## KITTTITAS COUNTY COMMUNITY DEVELOPMENT SERVICES

RE: BL-18-00010 #6 LLC

On September 19<sup>th</sup>, 2018, a Conditional Preliminary Approval Letter was sent for the above referenced BLA. The letter made reference to attached Public Works comments which were left out of the package in error. This is a copy of the letter with the comments included. Community Development Services is in receipt of the above referenced application. The application has been deemed complete and **preliminary approval** is hereby granted. Pursuant to Kittitas County Subdivision Code Chapter 16, please note the following items must be completed prior to final approval of the boundary line adjustment and must be submitted to our office for review:

TO: Community Development Services  
FROM: Taylor Gustafson  
DATE: September 14, 2018  
SUBJECT: Review of BLA BL-18-00010 (Carney)  
\*\* CDS Refers to this as #6 LLC

DRAWING TYPE: RECORD OF SURVEY

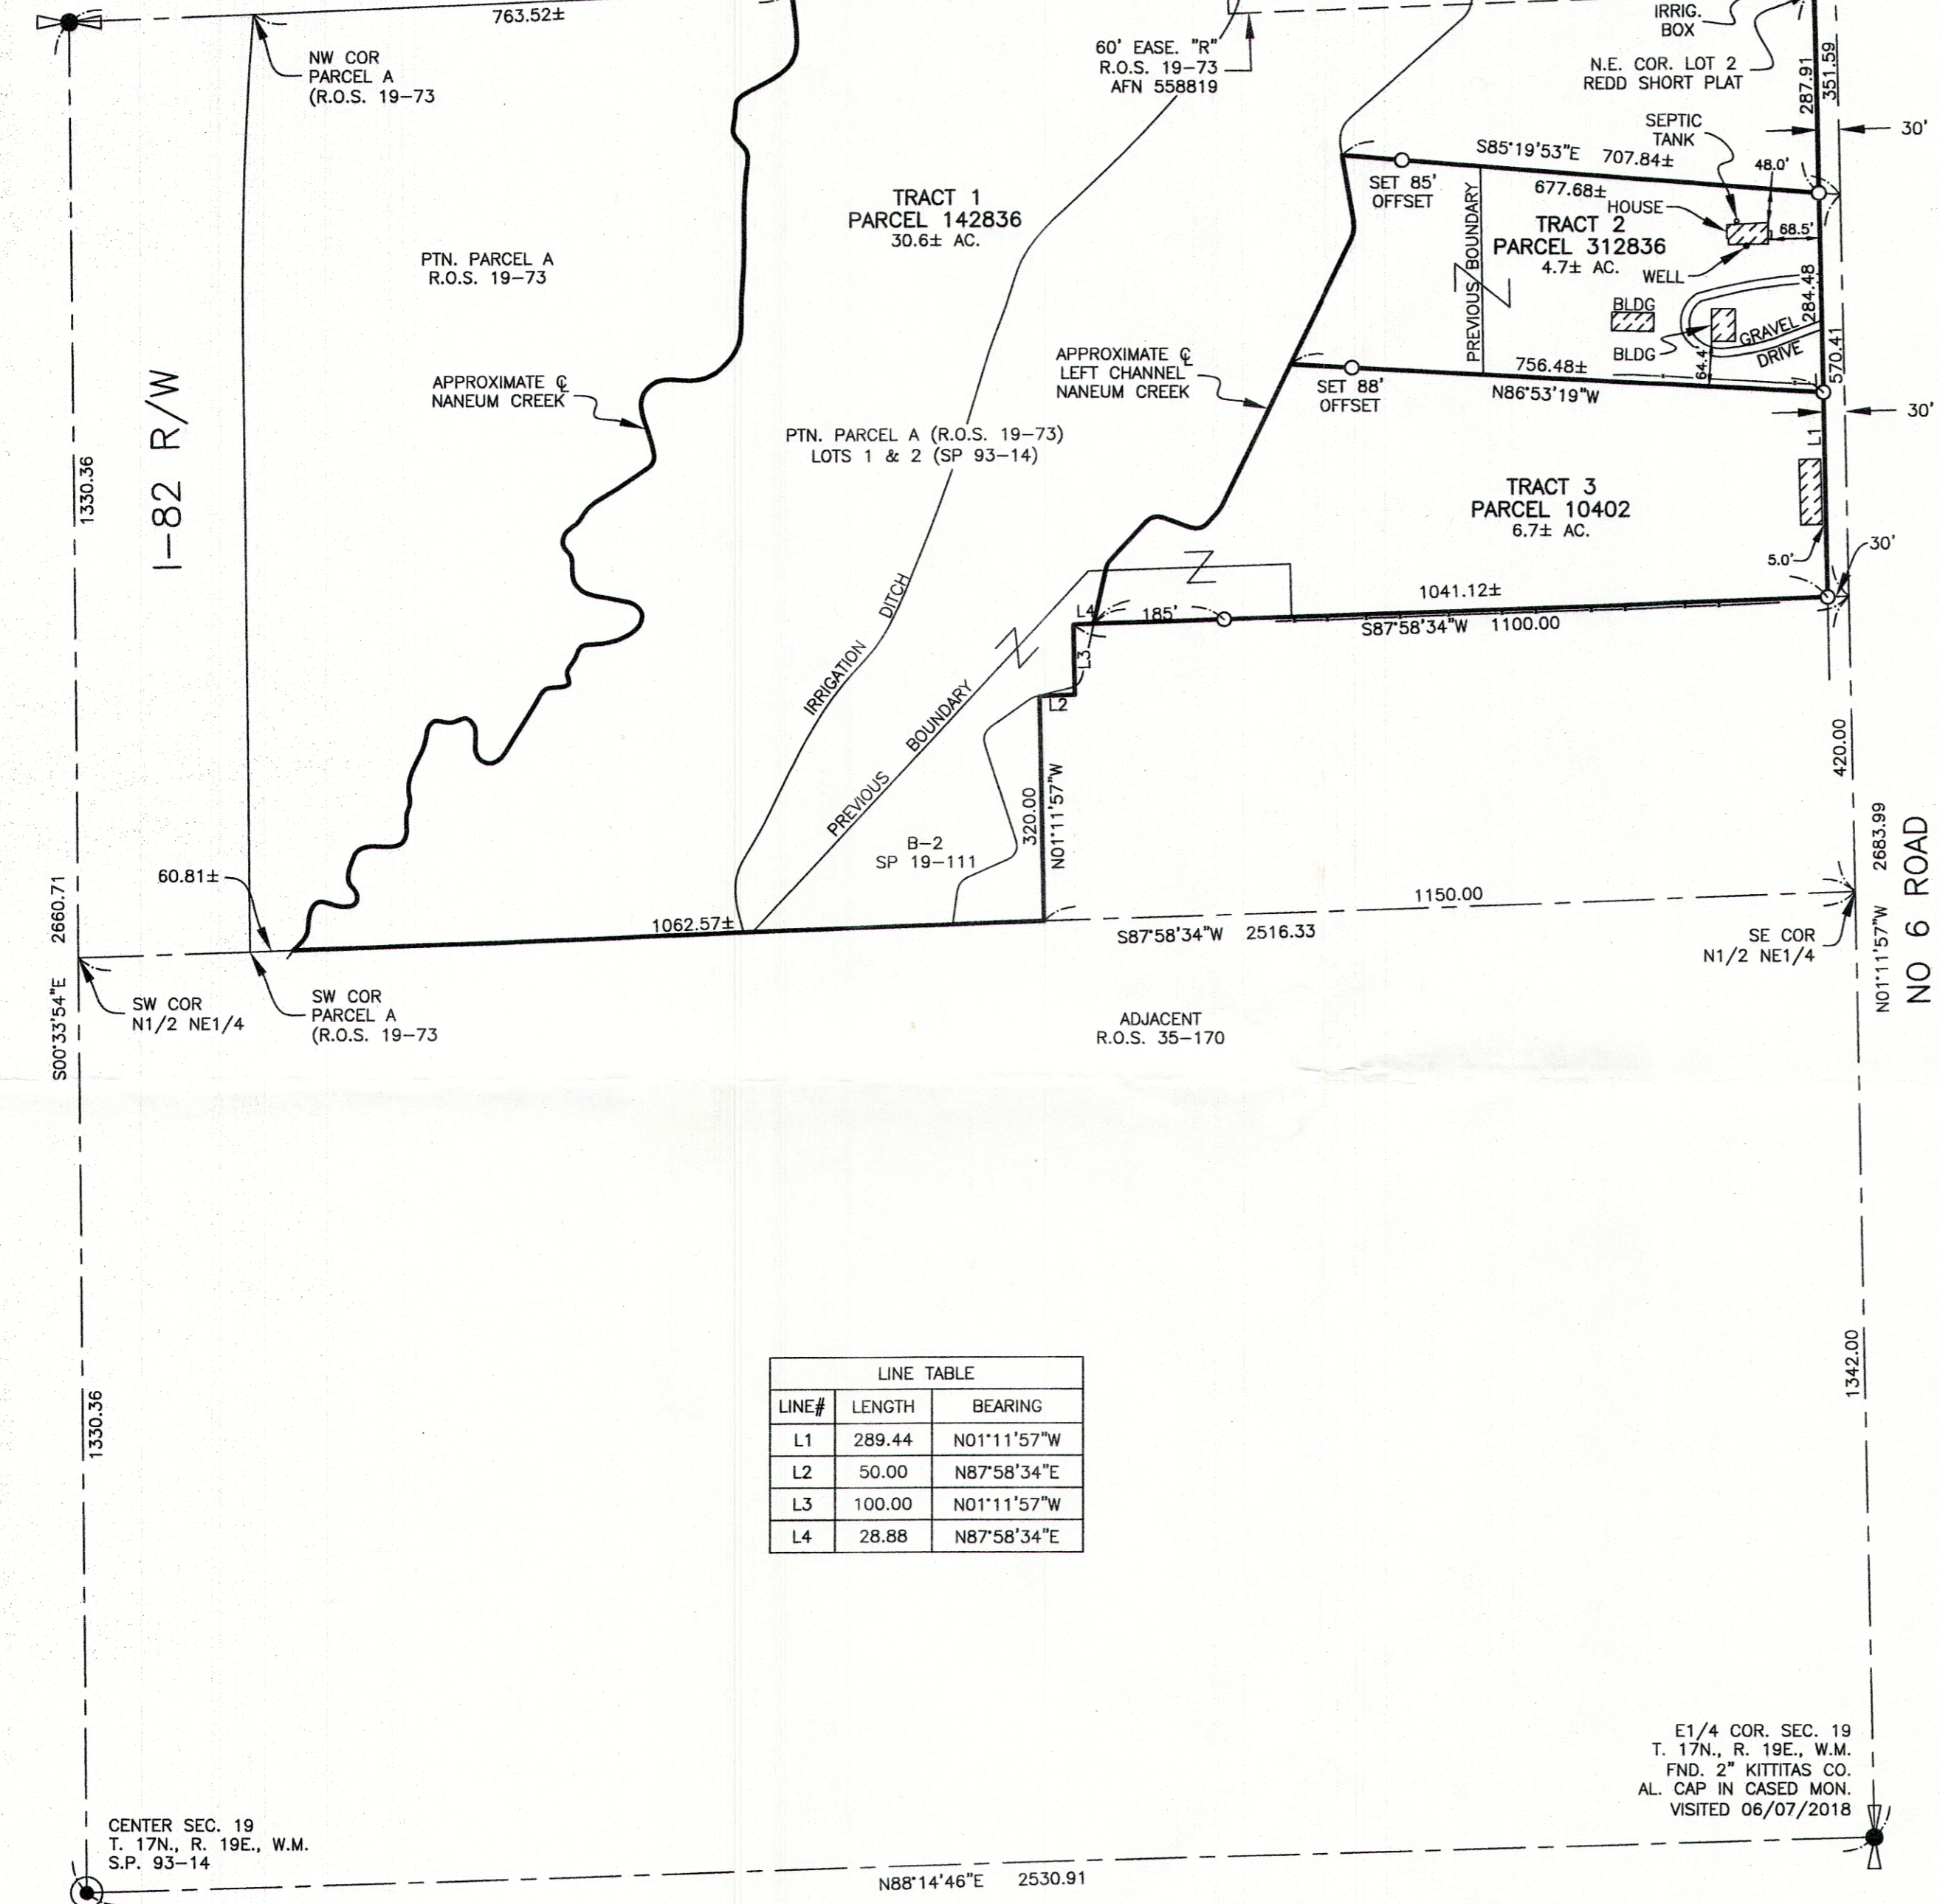
1. No. 6 Road, in this location, is classified as a Rural Minor Collector with a requirement for 300' spacing between access points. Please provide detail in regards to how this requirement will be met through this BLA

1. Basis of Bearing labeled or noted. (WAC:332130-050(1))b(iii))

2. All roadways should show name, width, underlying ownership and surfacing material.  
Ex. No. 6 Road (60' County R/W – Paved) (or similar)

3. A Purpose of Survey statement shall be included (KCC 16.10.020(1))  
Ex. The purpose of this survey is to illustrate and delineate the parcels shown hereon to facilitate the application for Boundary Line Adjustment BL 18-00010.(or similar)
